WEST SUSSEX COUNTY COUNCIL CONSULTATION

TO:	Arun District Council FAO:Miss Z Toppin
FROM:	WSCC - Highways Authority
DATE:	23 December 2020
LOCATION:	79 Arundel Road Littlehampton BN17 7DE
SUBJECT:	LU/311/20/HH Drop kerb 3 metre wide to enable off road parking for one car.
DATE OF SITE VISIT:	n/a
RECOMMENDATION:	Advice I
S106 CONTRIBUTION TOTAL:	n/a

SPLAY

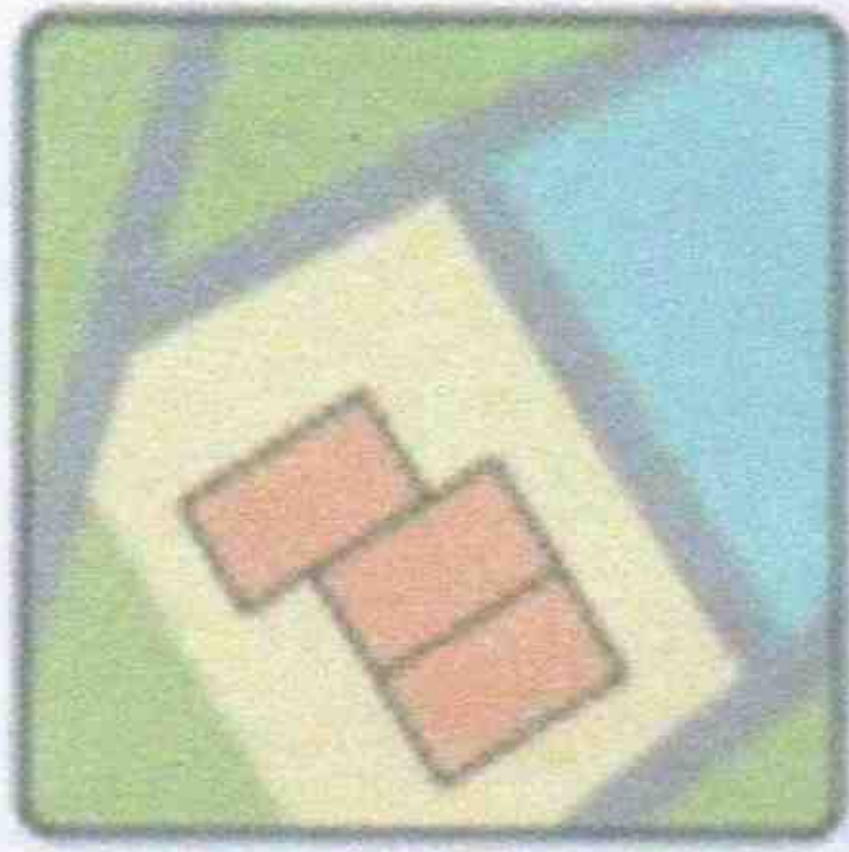
The applicant has demonstrated visibility splays at the proposed access using 2.4m 'X' distance, however splays seem to intersect with third party ownership. Local mapping indicates that splays drawn at 2m 'X' distance would be sufficient for the posted speed limit. The access point benefits of good forward visibility.
